From: Grant, David
Sent: 01 February 2022 08:45
To: _planningadvice
Subject: FW: 3 Malting Lane H04-0634-21
Attachments: Trial hole 1.jpg; trial hole 2.jpg; TP.1 Storm BRE 365 perc test Garrett Barron.pdf; Tp.2 Strom perc test BRE365 Garrrt Barron.pdf

Subject: RE: 3 Malting Lane H04-0634-21

3 MALTING LANE H04-0634-21 – SOAKAWAYS

SITE PLAN 1/500

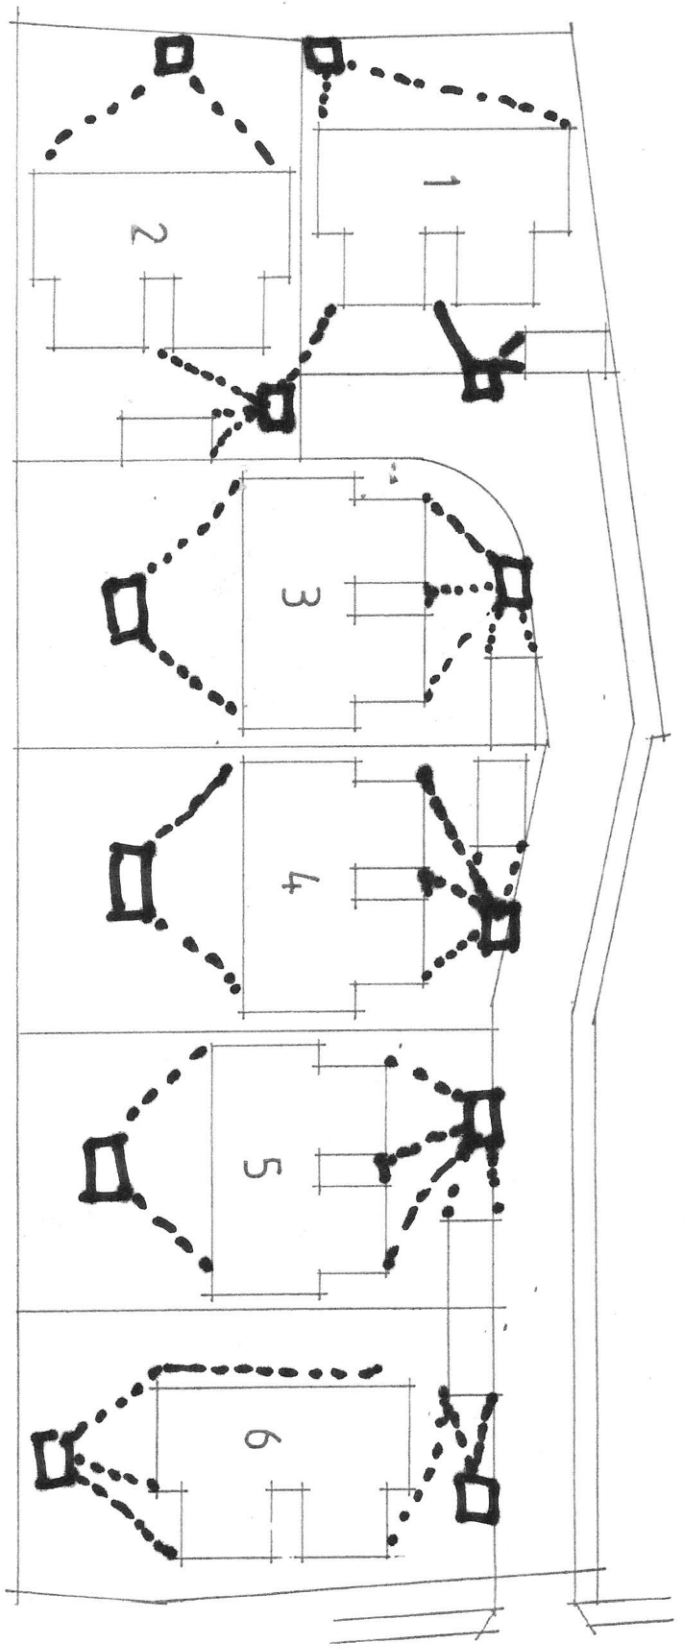
From a Building Control perspective this is the results of the percolation test with some recommended soakaway sizes. I would expect some drawing or specification of what the proposal of sizes and positions for the actual soakaways on the site.

Thank you for your email dated 09 November 2021 12:08, and I attach the results of the percolation tests. Each soakaway will be positioned a minimum of 5 metres from any building.
